Subject: Shoreline Exemption Permit, Pump Station 1- 8002 SE 20th St.

This is a written response to the review comments provided by the Community Planning and Development Department regarding the application for the Shoreline Exemption Permit, SHL23-007, for Pump Station 1 located at 8002 SE 20th St.

PUMP STATION 1 -
PLAN

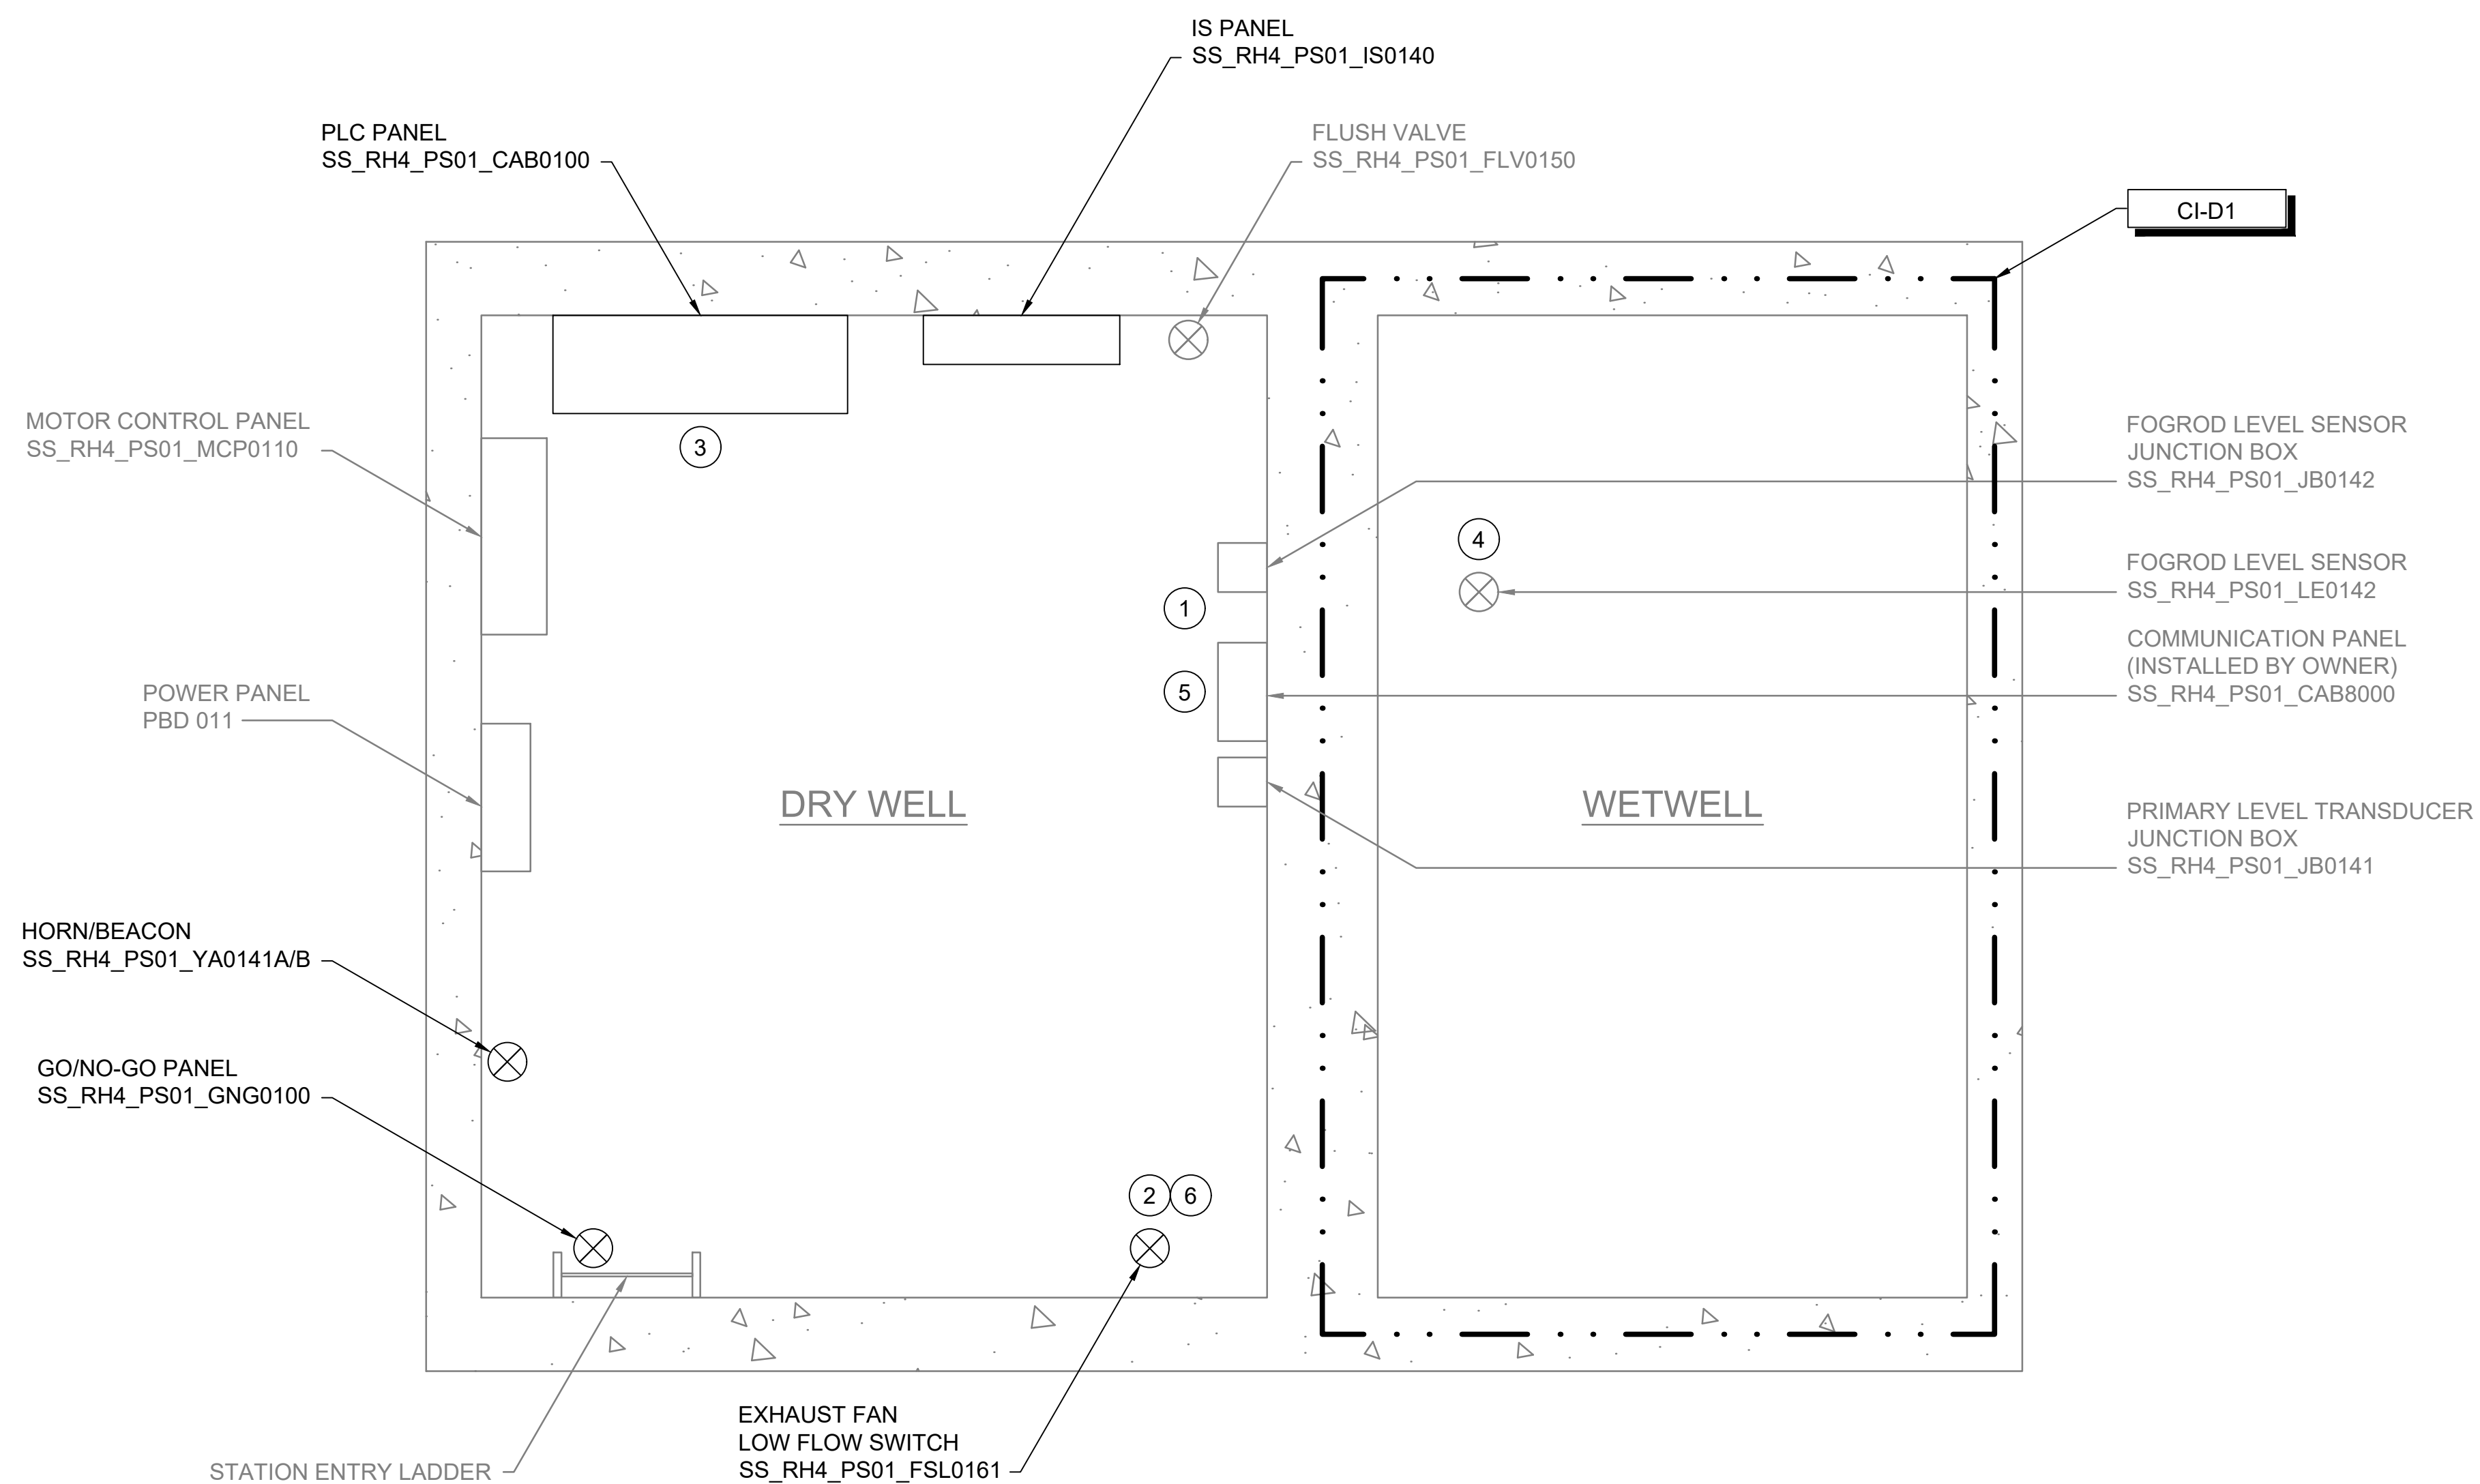
- a. Provide address of all pump stations on plans

Response: *The address for the pump station has been added to Development Plan, Instrumentation Drawing page 1. The address was also included in the aerial photo of the pump station.*
